CAWSTON PARISH COUNCIL SUBMISSION FOR DEADLINE 3 – COMMENTS ON DEADLINE 2 SUBMISSIONS

Cawston Parish Council

18th December 2019

CAWSTON HIGH STREET - INTERVENTION SCHEME  
Scale 1:500

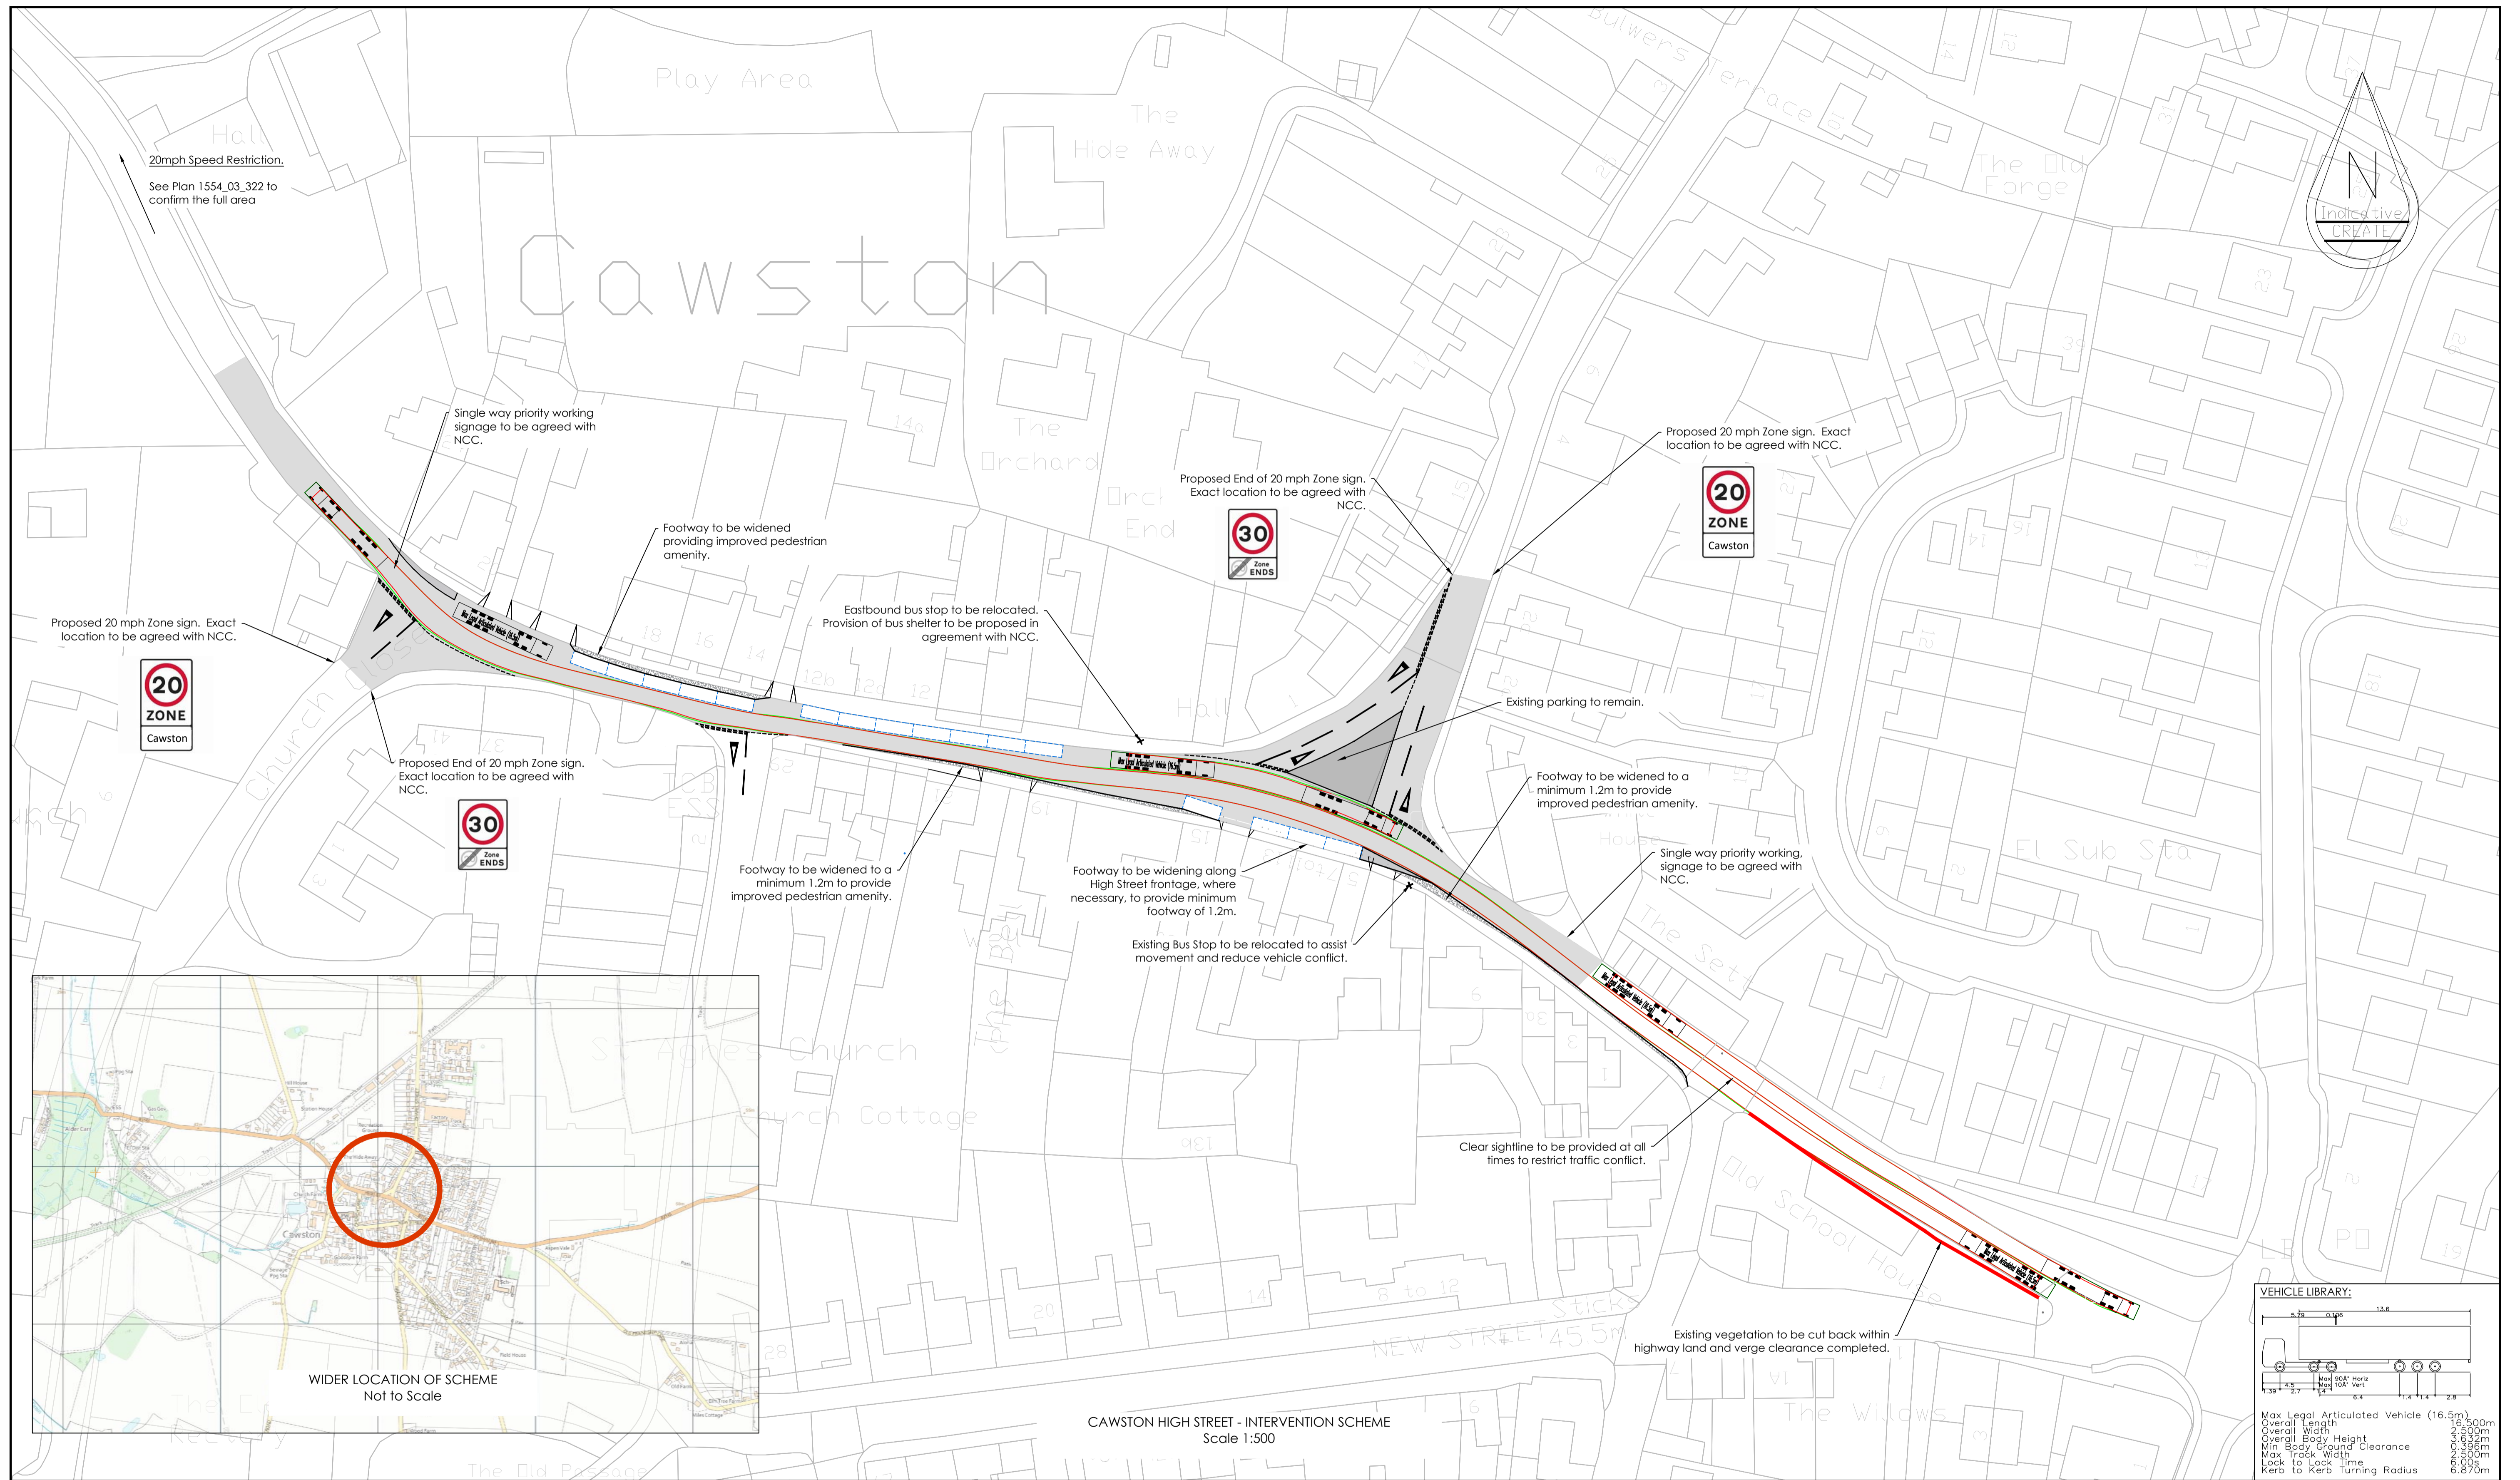
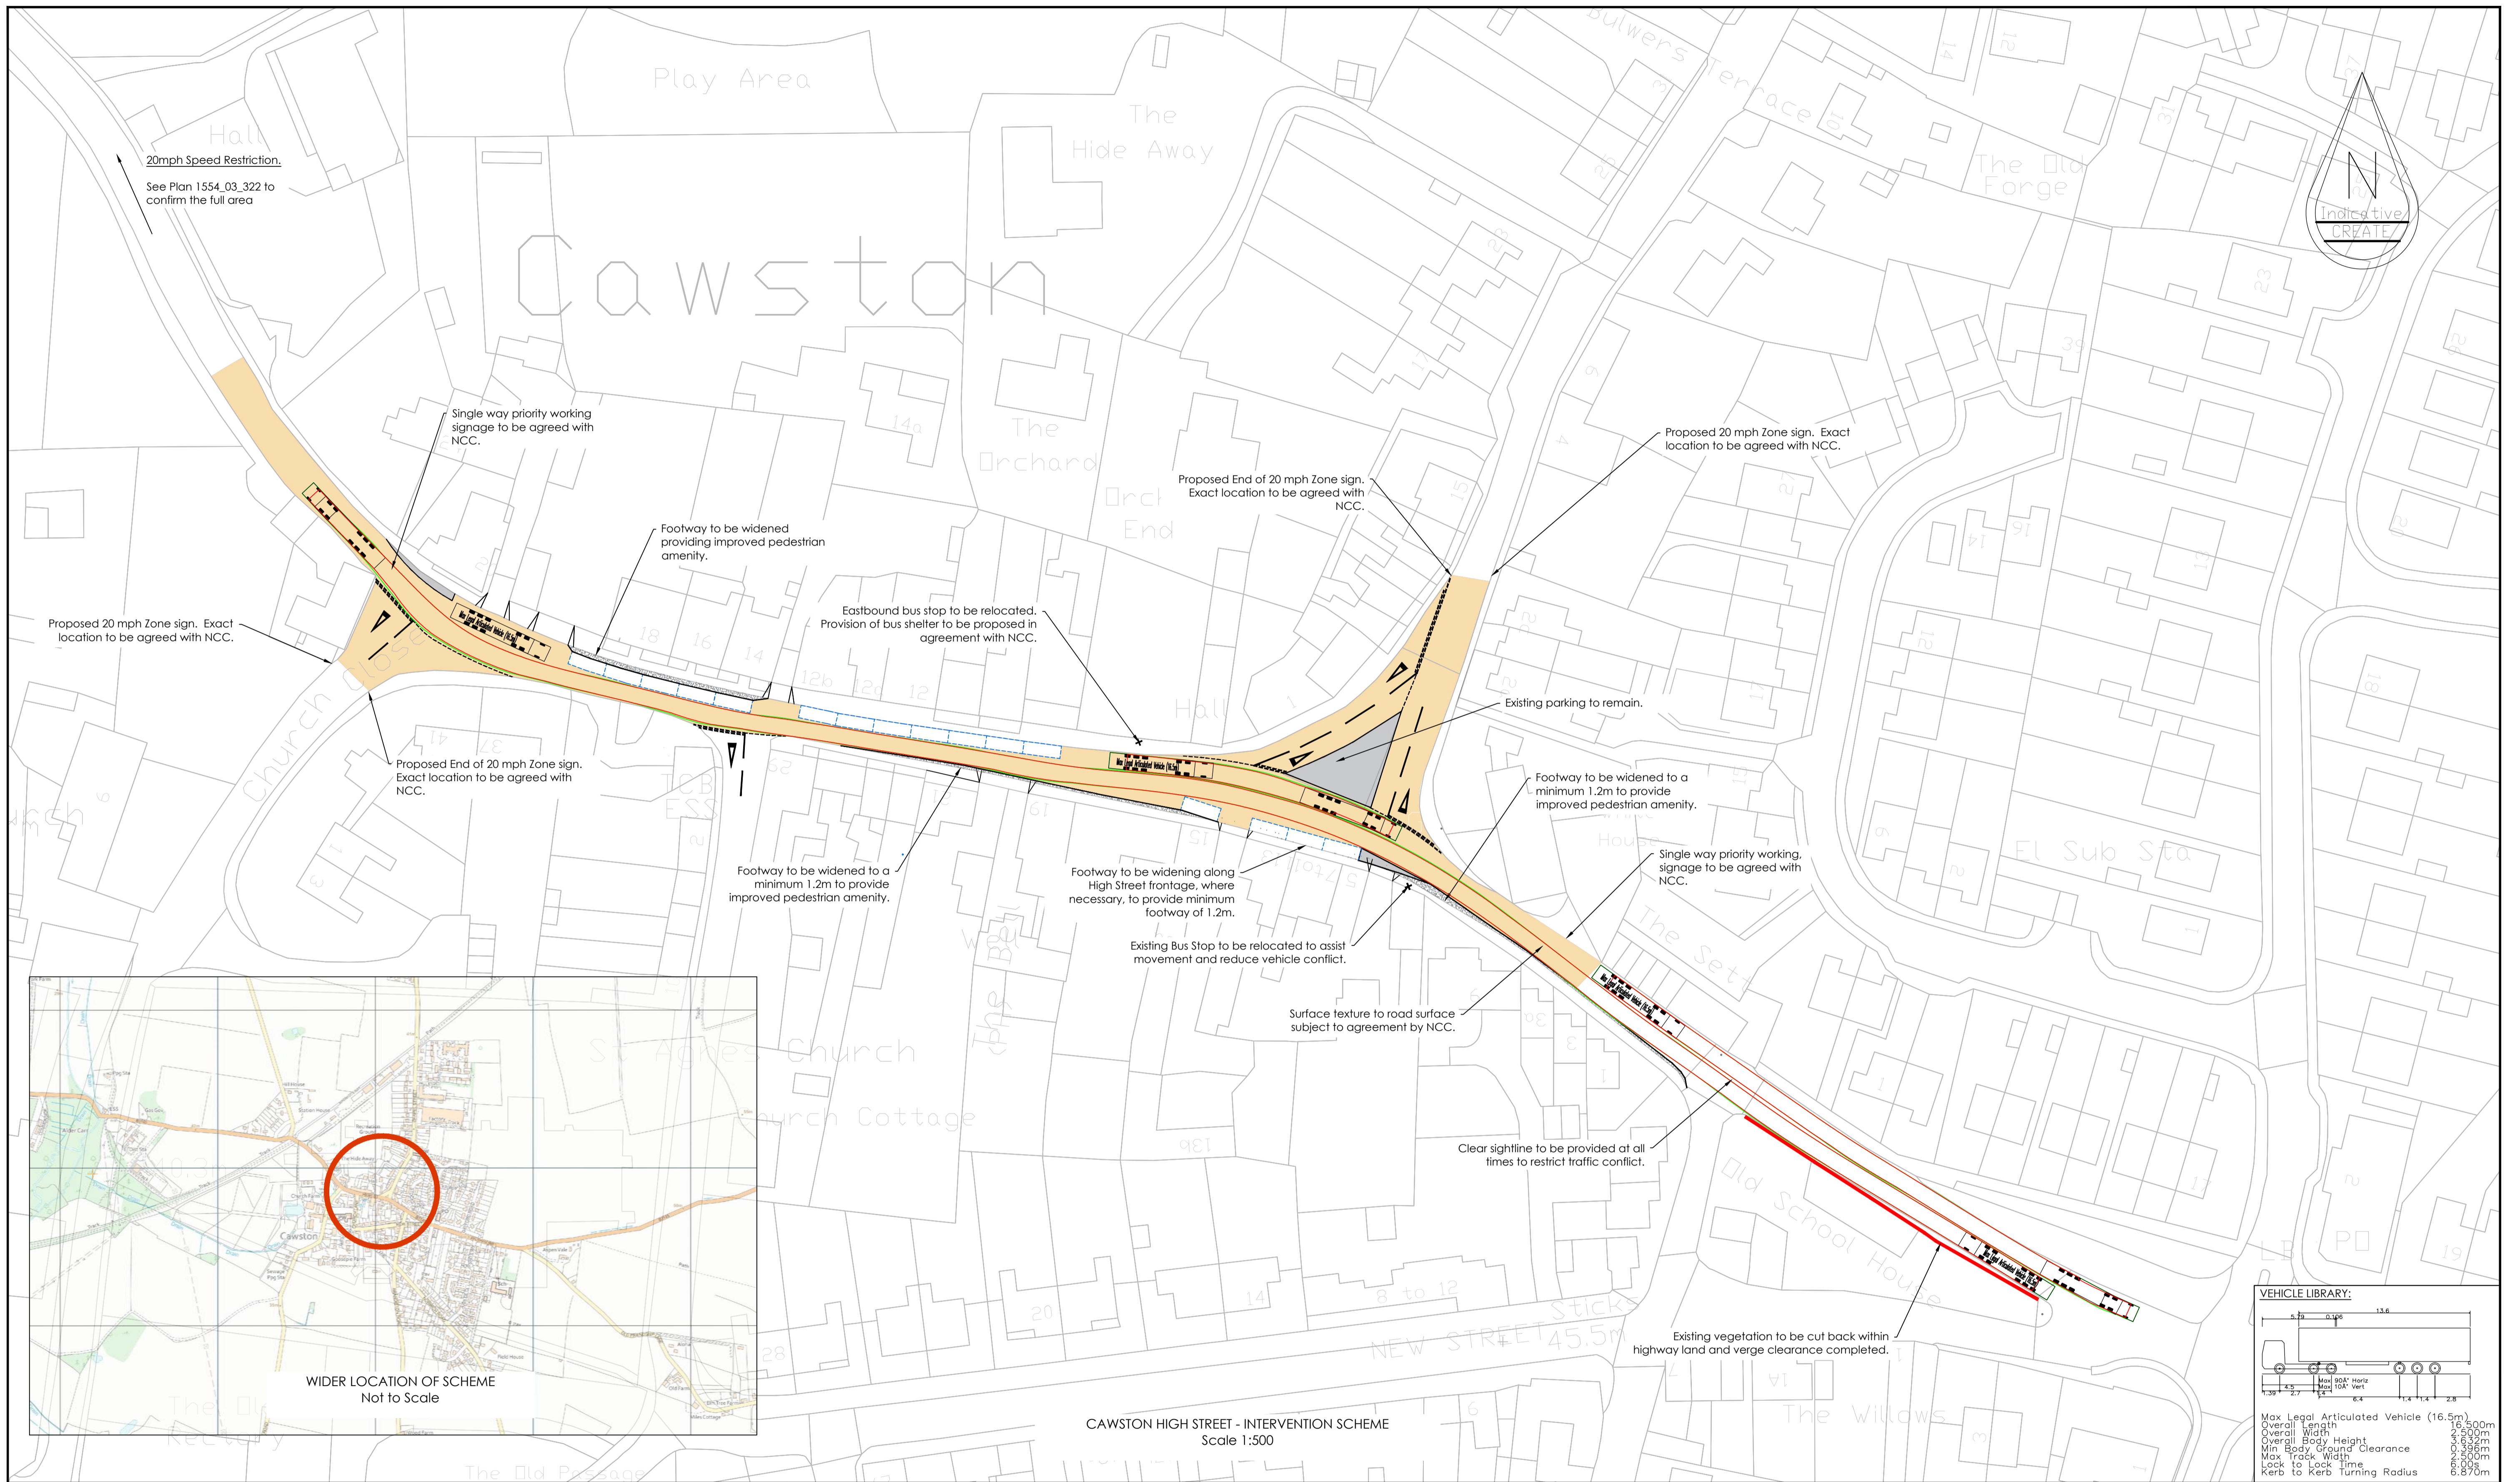
All we can see in the multitude of items submitted by Boreas is a reliance on repeating the plan created by Orsted over several versions and discredited during the Vanguard Inquiry. As an example, a recurring theme is the benefit to residents of promised footway widening. From our meeting with Vattenfall on 22nd November we understand that this has now been completely removed from the plan so we are at a loss to understand how the Applicant still emphasises it as mitigation in so many other documents. As an example, please see [EN010087-001458] the SOCG with Broadland DC.

The one new feature quoted is a suggestion of enhanced street lighting in the High Street. Neither Cawston PC, NCC nor BDC have requested this, so we are puzzled as to why it has appeared.

Any repair or rebuilding work, or even safety measures needed to repair any temporary and reversible damage would need to be carried out whilst the B1145 was being used by the Applicant's HGVs and light vehicle movements. The applicant's plans remain to create a "rural clearway" through the centre of Cawston, which Cawston Parish Council continues to regard as unworkable and dangerous. These plans do not account for the

It is worthy of note that the Position Statement with Broadland District Council quoted by the applicant continues with "Concerns were raised with respect to footpath widening near Grade II Whitehouse Farm resulting in a narrowing of the carriageway and increasing the risk of potential collision."

In the following sentence, in the smallest typeface available, the applicant goes on to state that "concerns regarding the footpath widening are being reviewed as part of the development of the highway mitigation scheme". Cawston Parish Council presumes this sentence refers to the applicant's recent consultation with CPC representatives where it was suggested that all pathway widening should be removed from the next version of the highway mitigation scheme. The widening of pathways was introduced in the very first version of the highway mitigation scheme in an attempt to protect any pedestrians brave or unfortunate enough to be walking on pathways in Cawston when the applicant's, and other wind farm developers' HGV traffic was trying to pass on the inadequate B1145 in the village.
